**Application no: 22/00217/DISC**

**Location: Begbroke Science Park, Begbroke Hill, Begbroke, OX5 1PF**

## **Lead Local Flood Authority**

Objection

**ZONE B CATCHMENT AREAS PLAN**

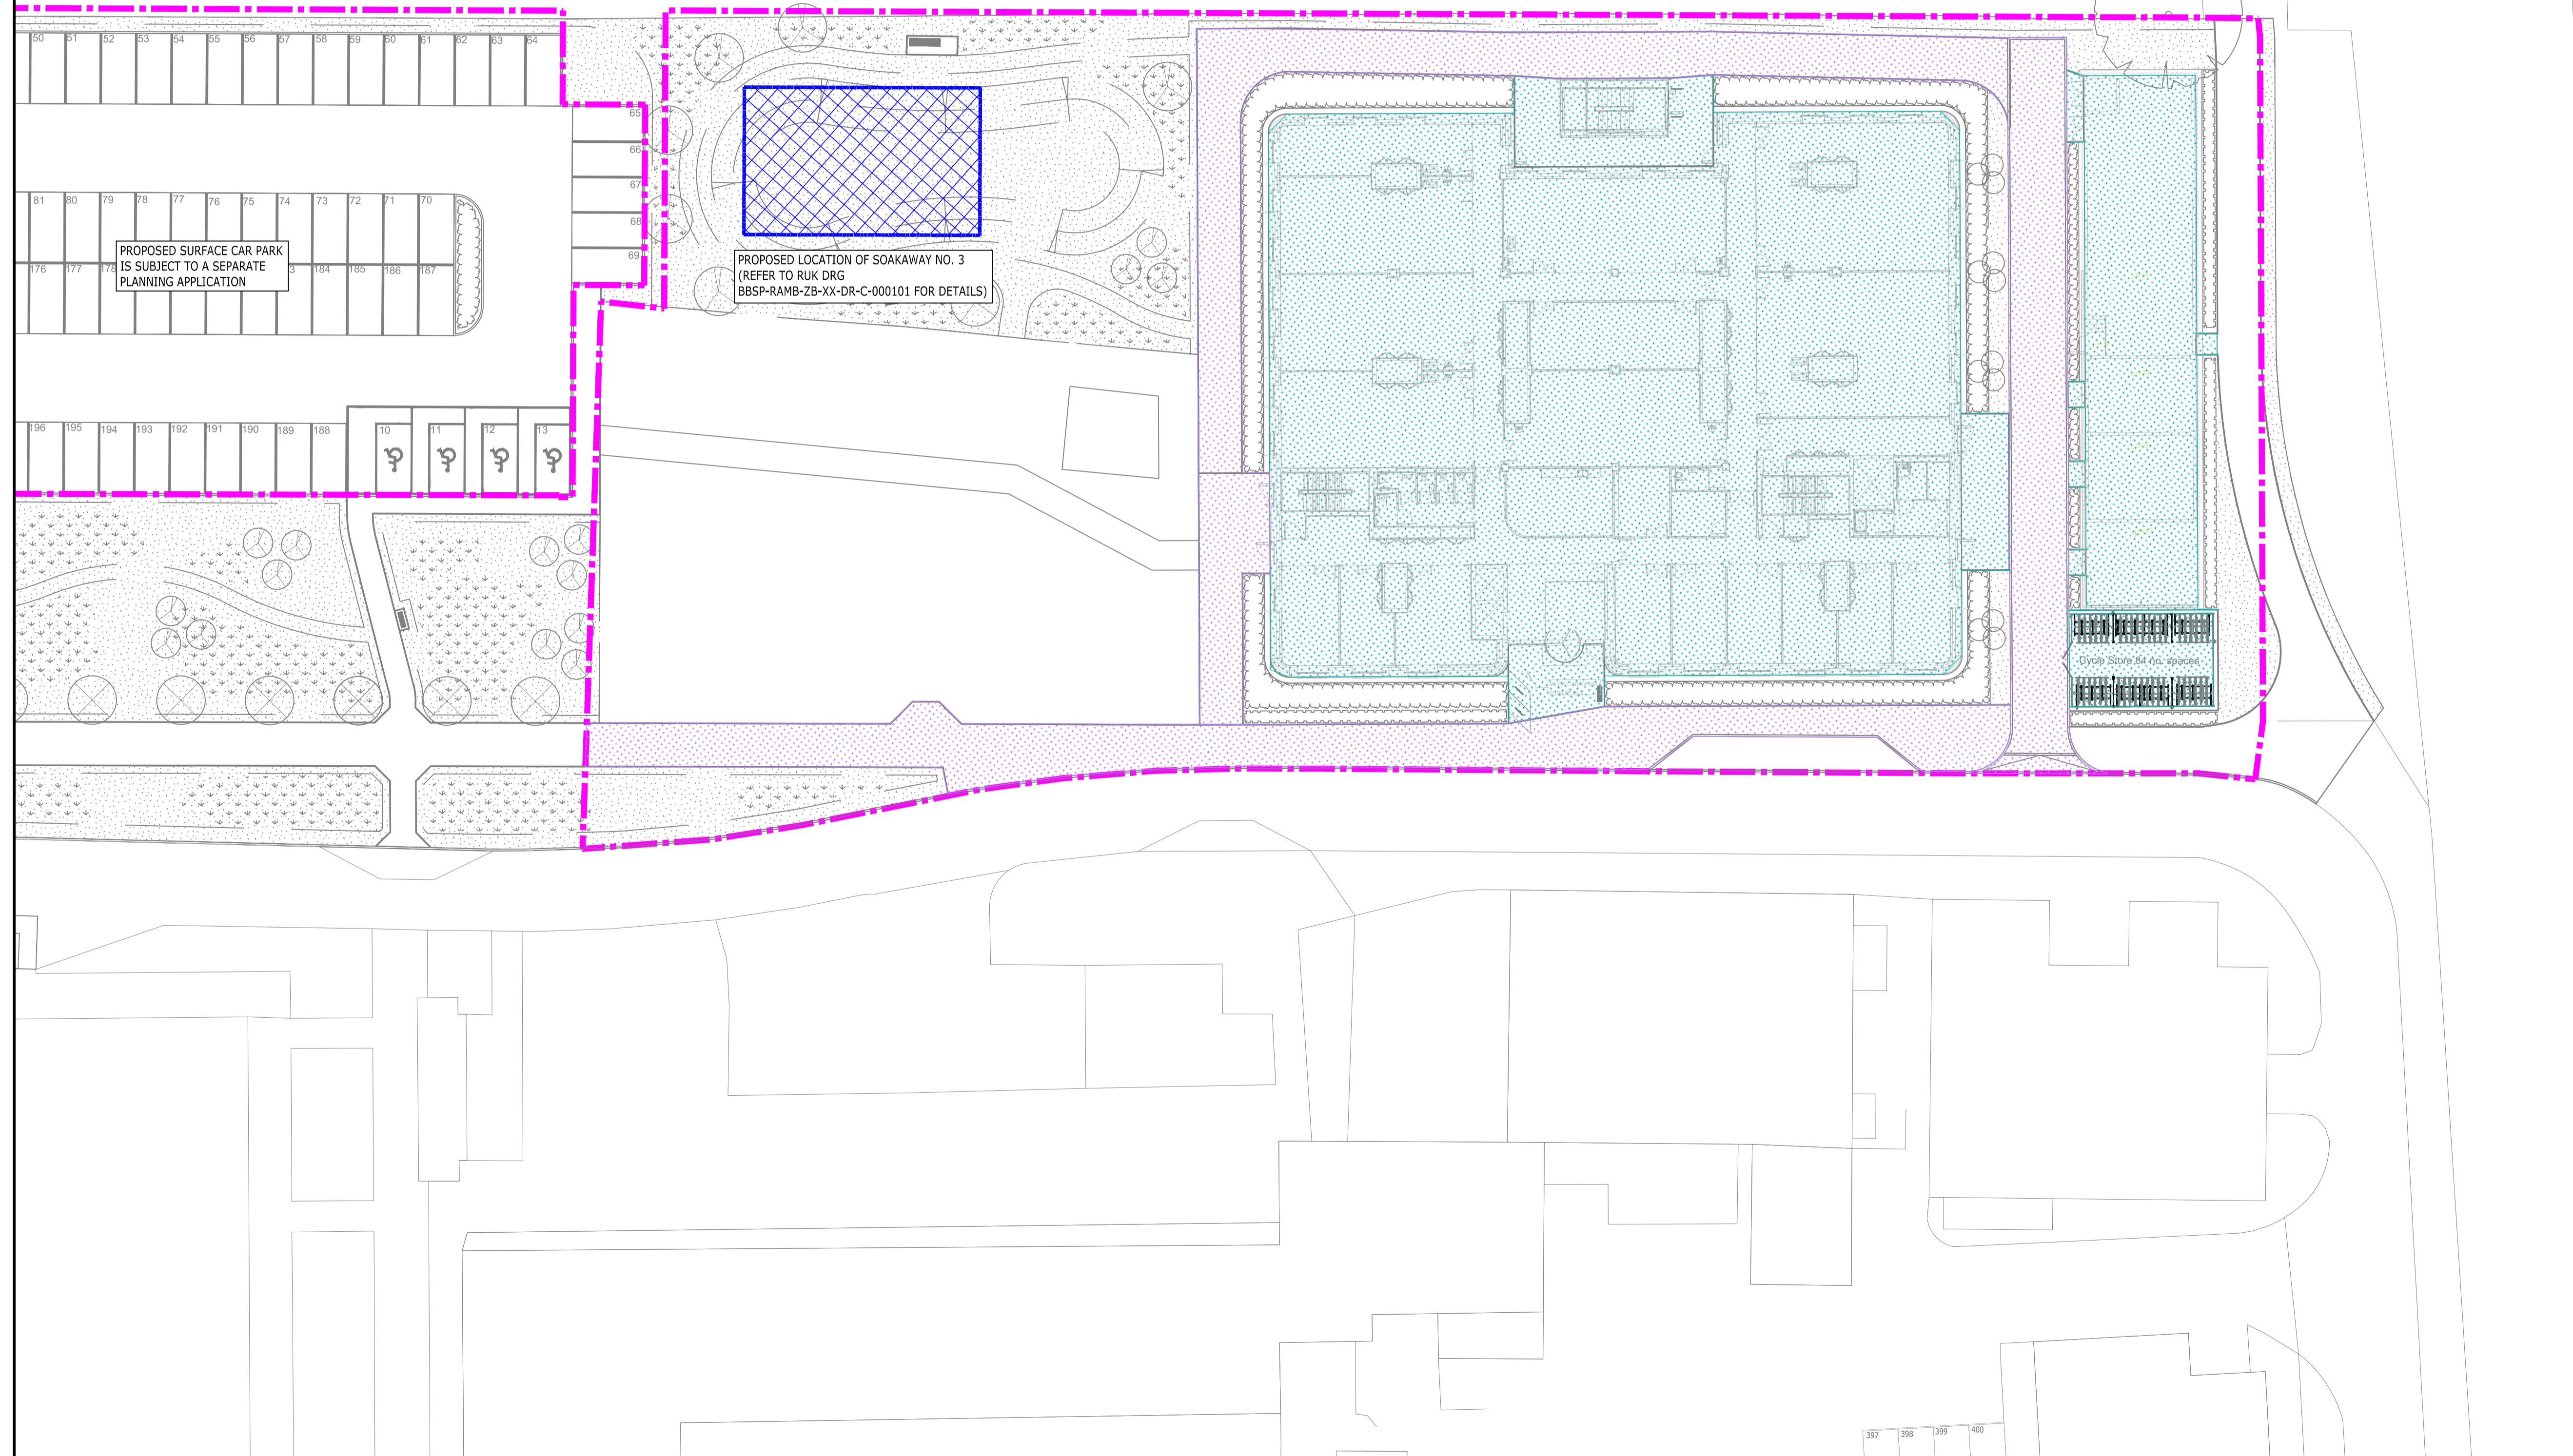
- o Discharge Volumes  
Discharged according to: Micro Drainage calculations, 10/09/2021
- o SUDS (Soakaways)  
Provide catchment plan, showing the extent of the impermeable areas and stating the area.. There is a soakaway proposed outside the site boundary, please clarify ownership of this land and whether the proposed soakaway is acceptable.

**ZONE B INDICATIVE SURFACE WATER DRAINAGE LAYOUT**

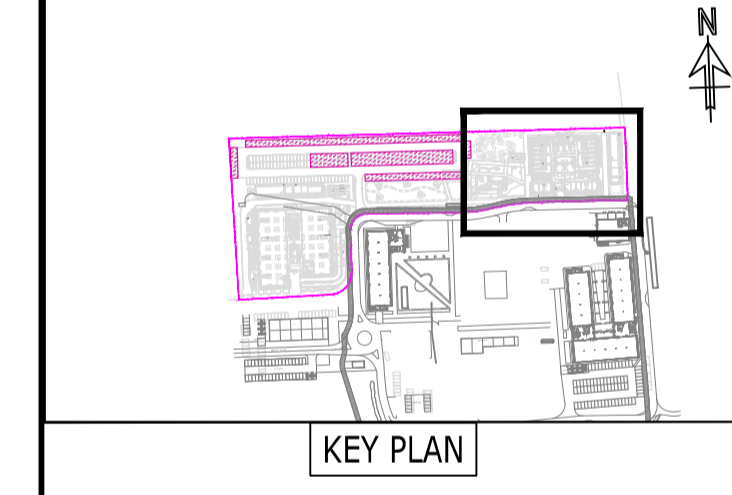
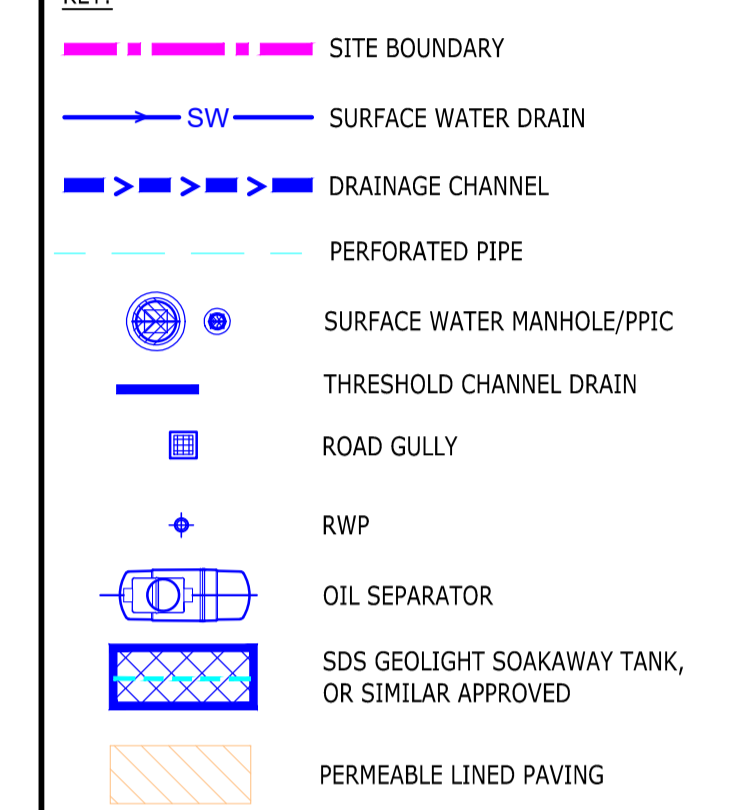
- o Detailed drainage layout with pipe numbers  
Provide pipe numbers. Calculations should reflect the pipe references. Include pipe numbering on the drainage strategy drawings.
